# BUILDING PERMIT

Located At 314 LUDLOW ST.

Job ID: 2011-08-1874-ALTR

has permission to Construct an attached two (2) car garage/ addition.

A-1.1

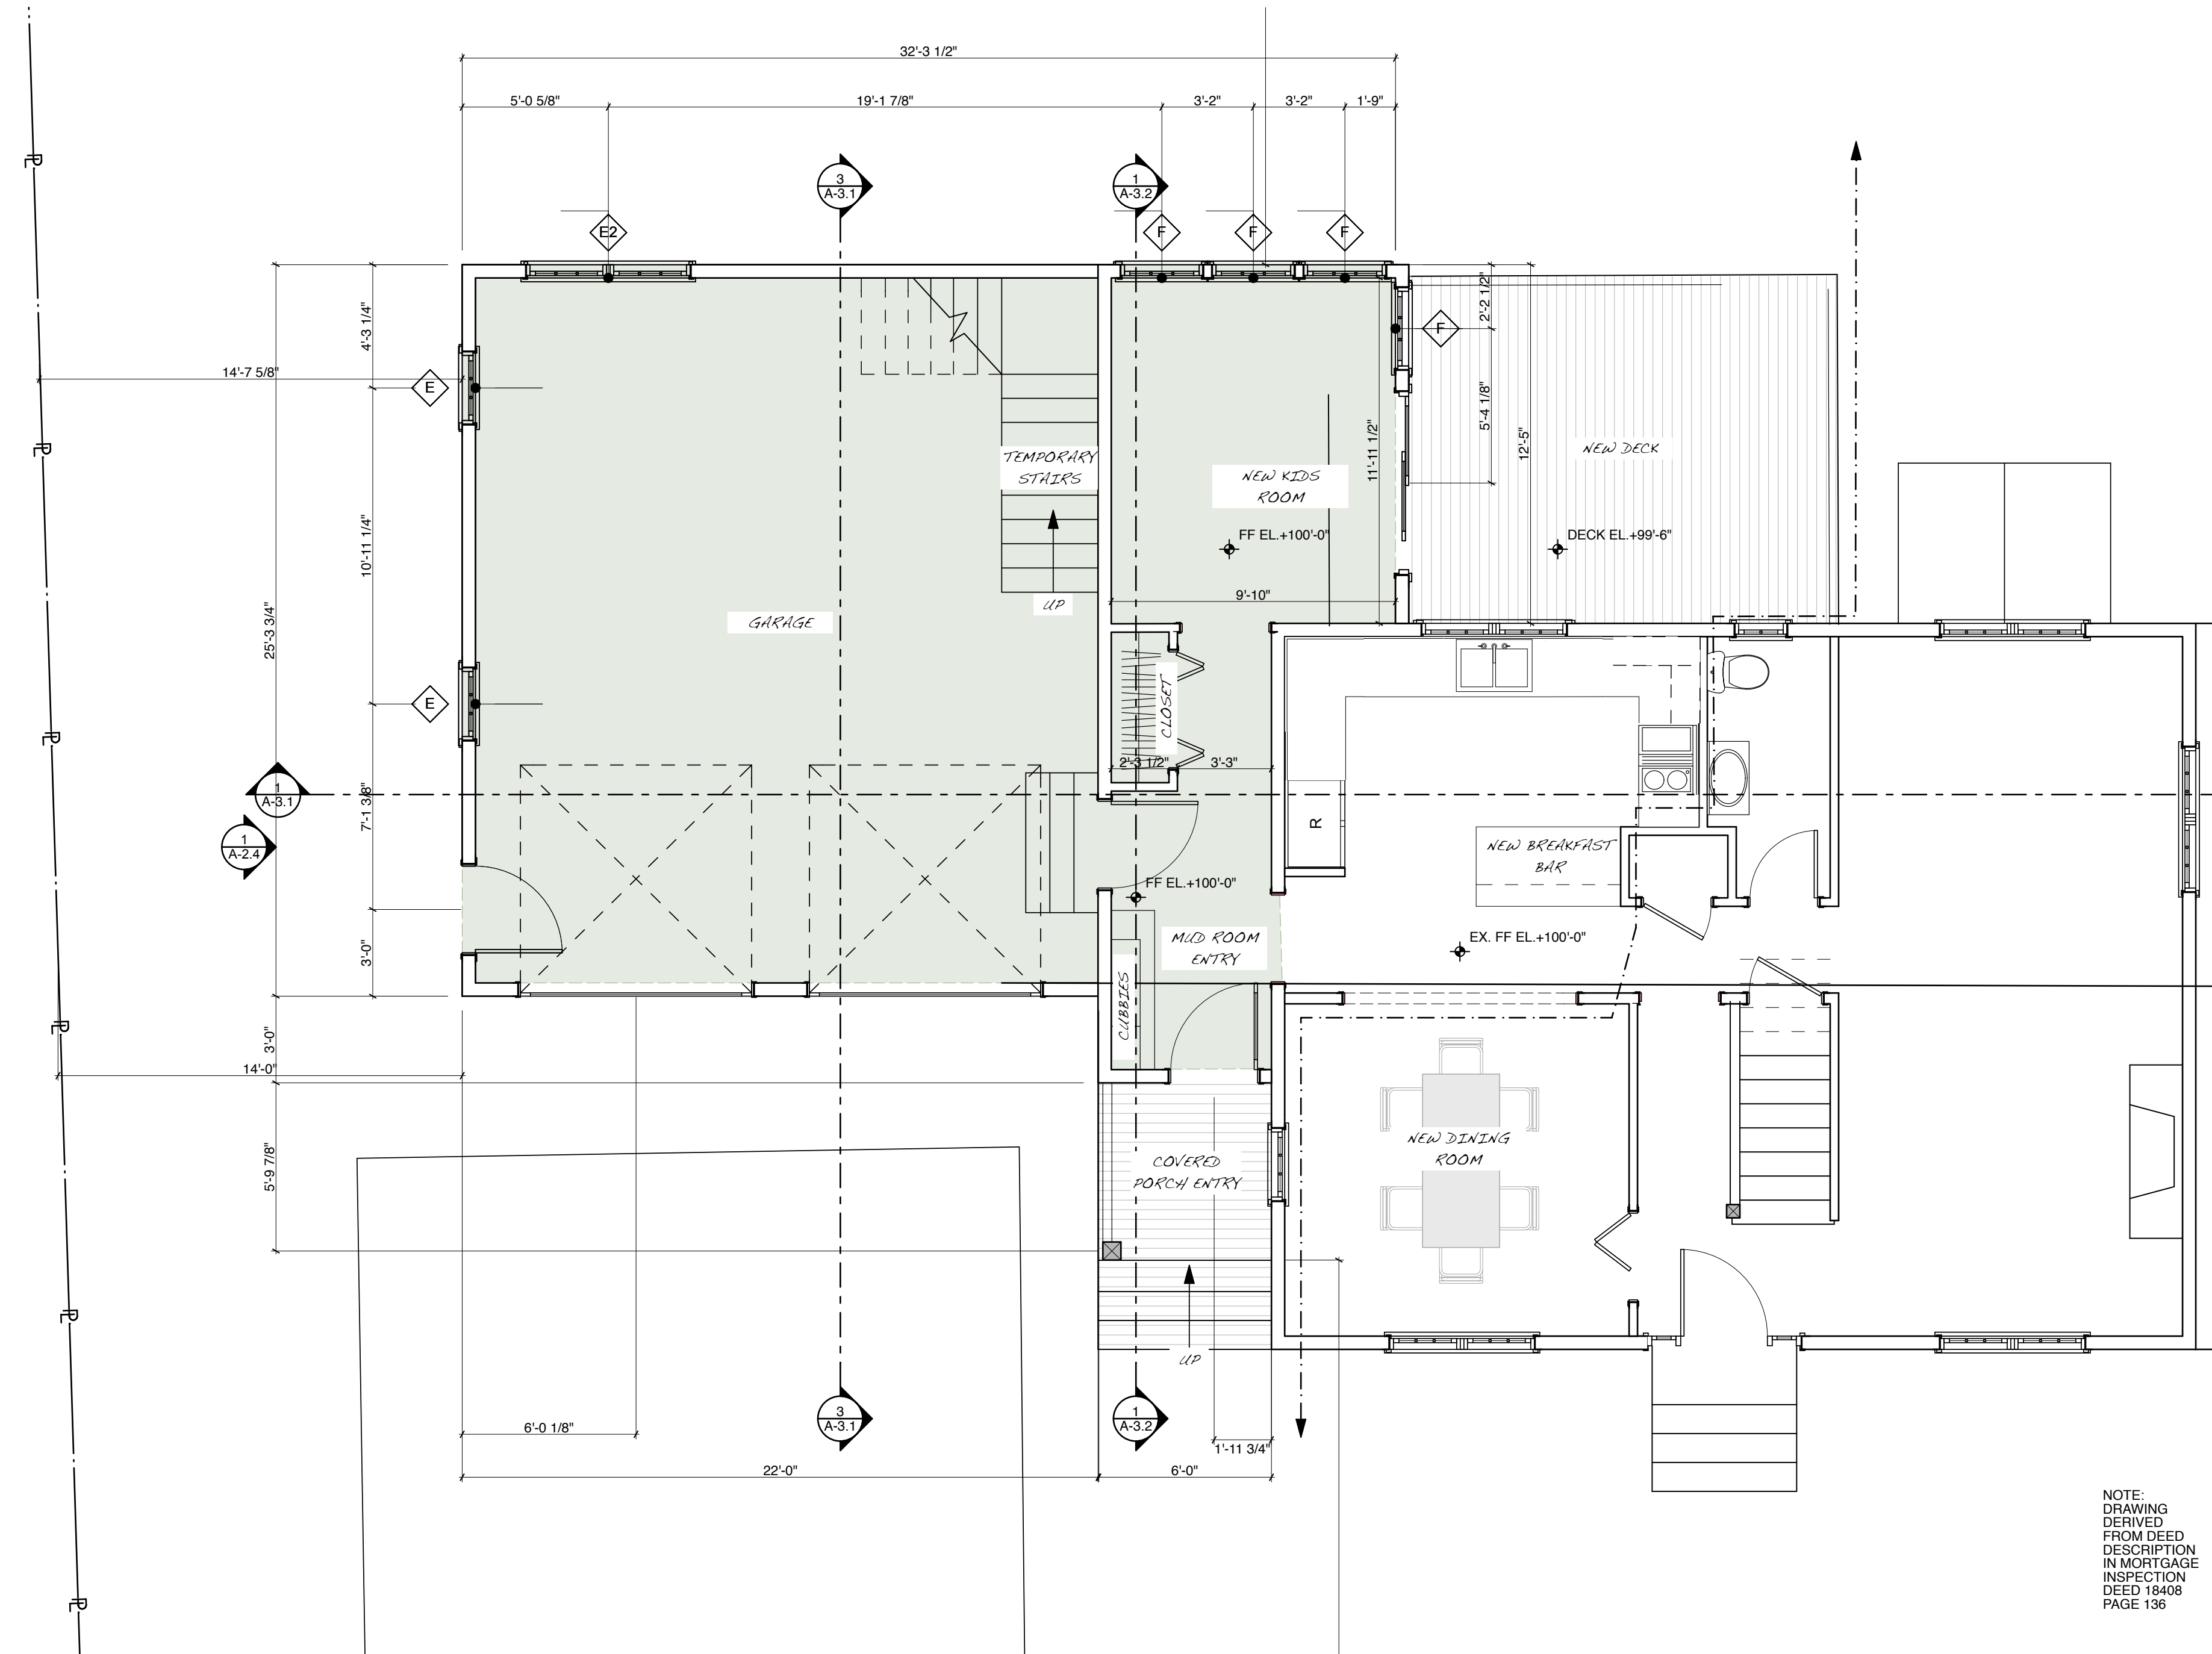
Footings Dimensions/Depth  
(Table R403.1 & R403.1(1), (Section R403.1 & R403.1.4.1)  
A-1.1 is the foundation plan (4' 6" min below grade)

Foundation Drainage, Fabric, Damp proofing (Section R405 & R406)  
Sheebo, min 4" diam, perf drain, min 6" crushed stone and geotech wrap

A-1.2

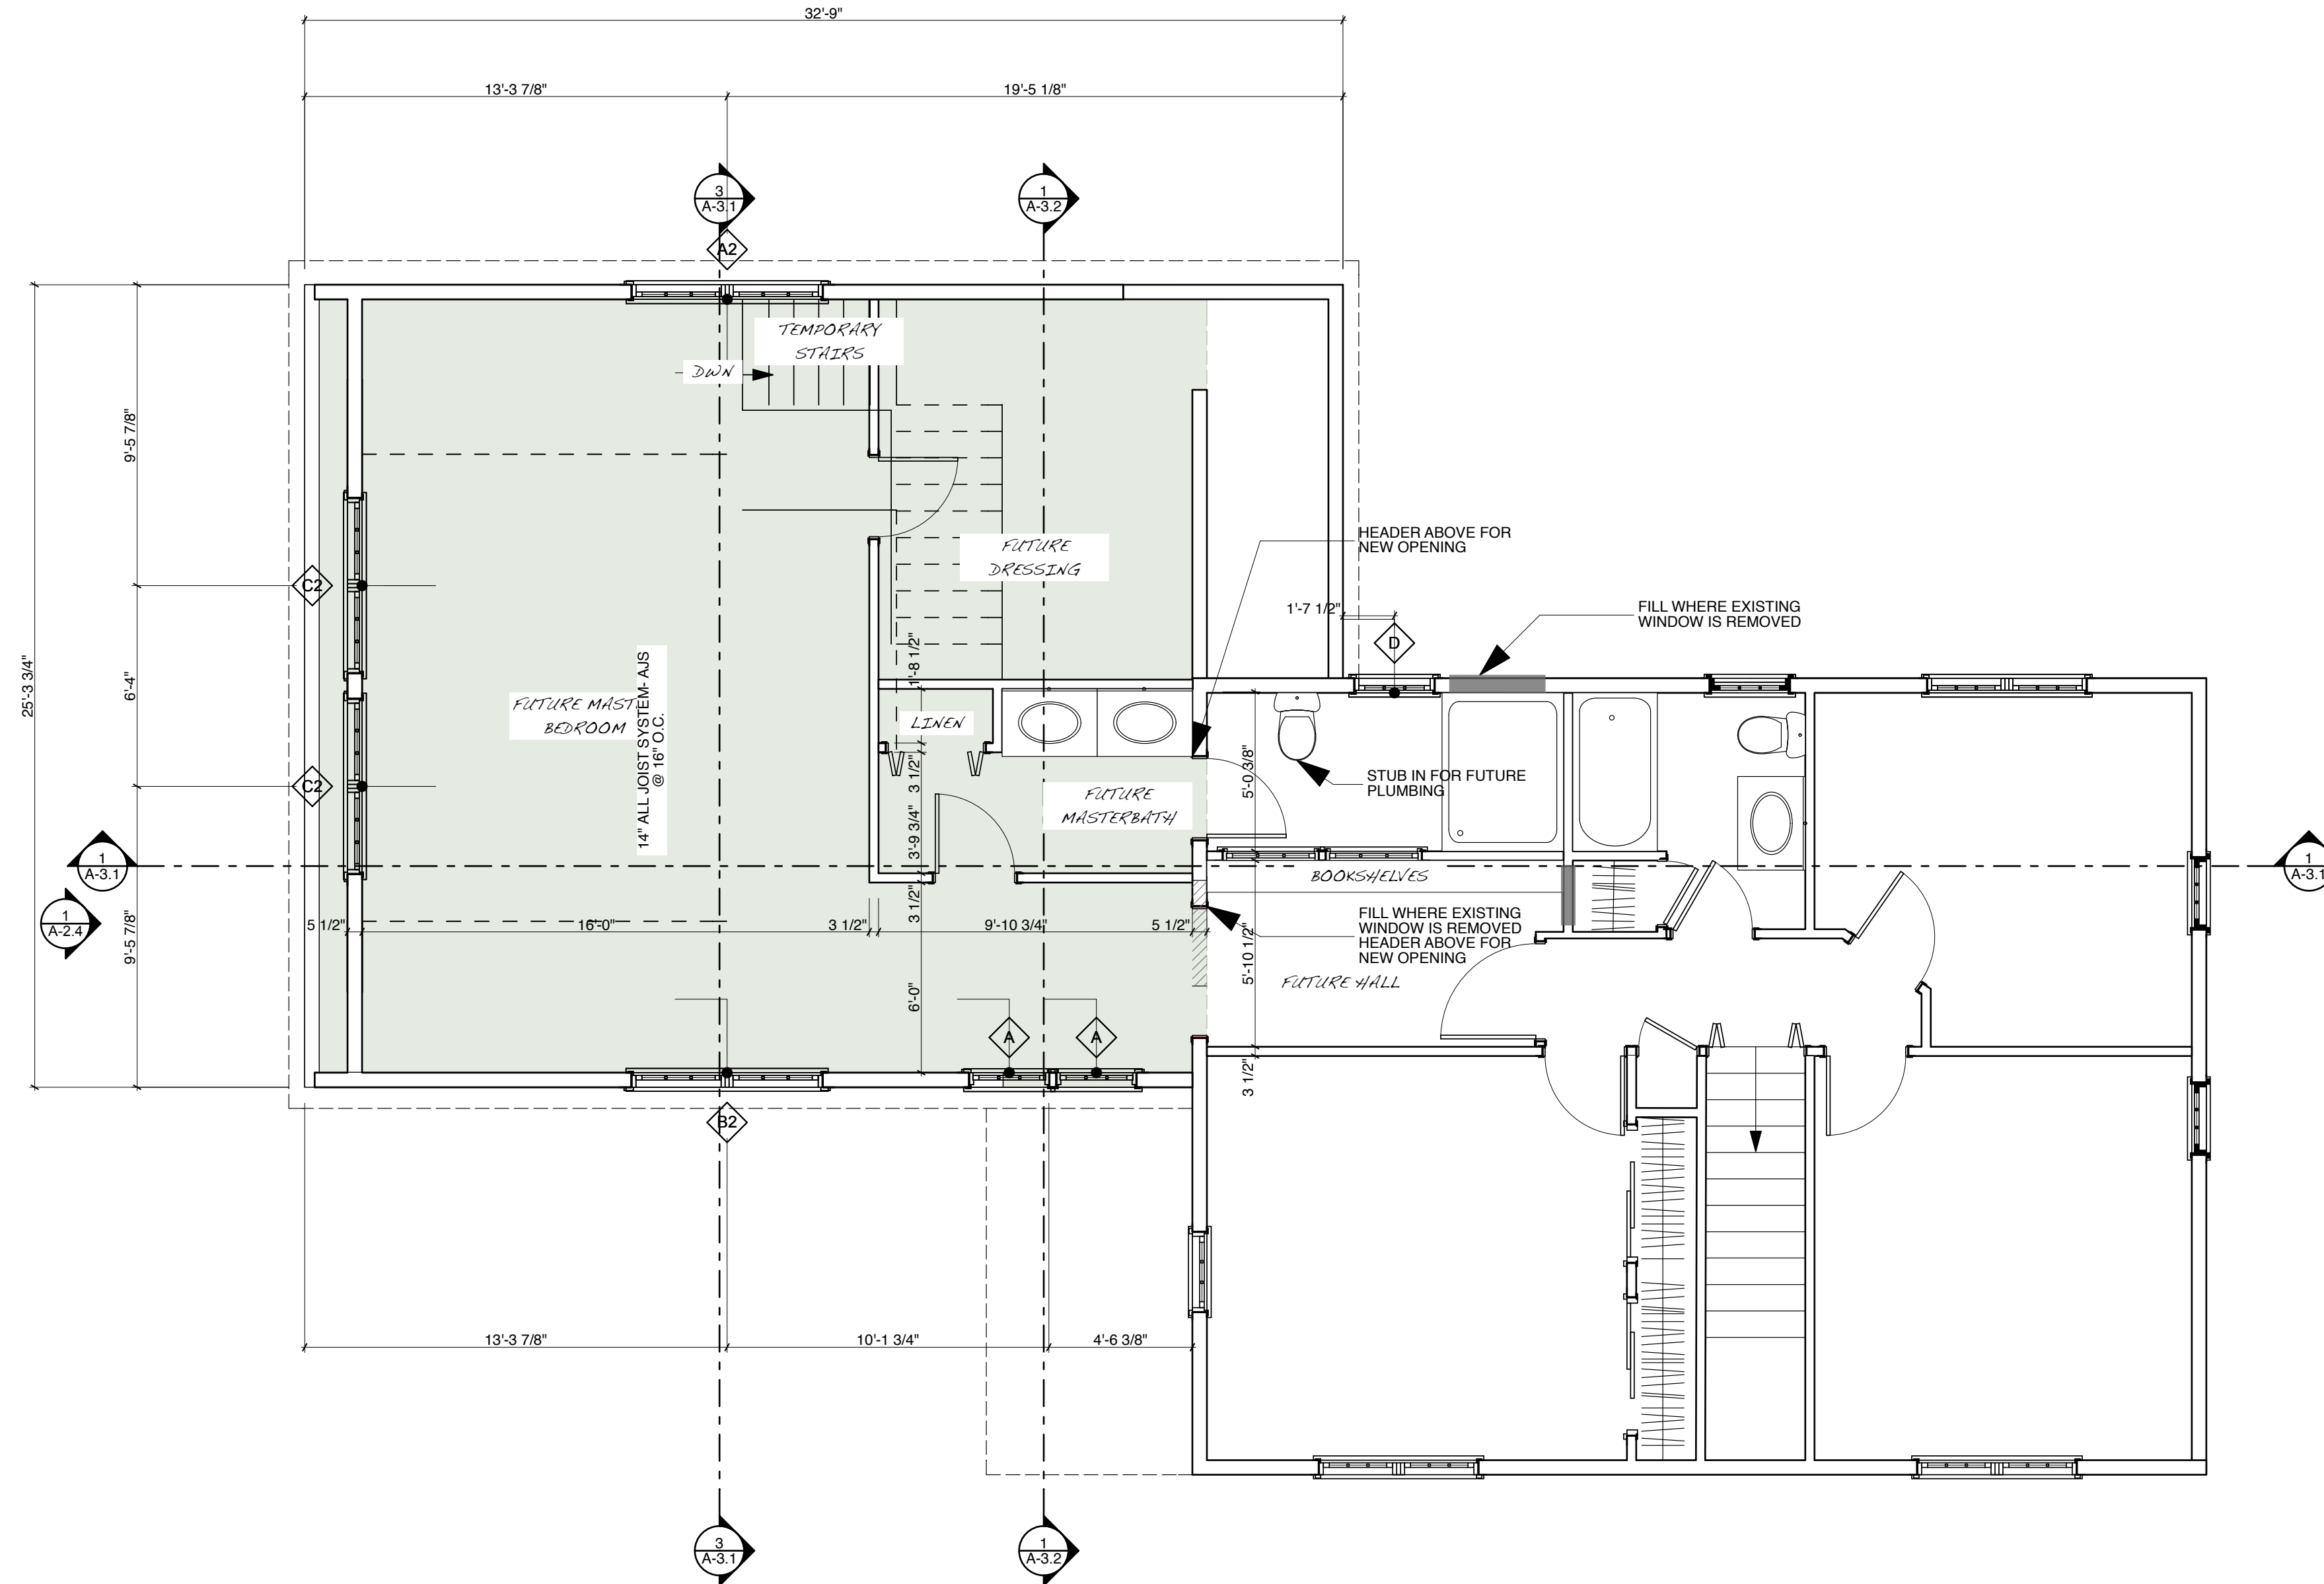
Fire Separation (Sec. R309.2, and Openings R309.1): Fire Door provided?

Fire Rated Door A-1.2, and A-3.1
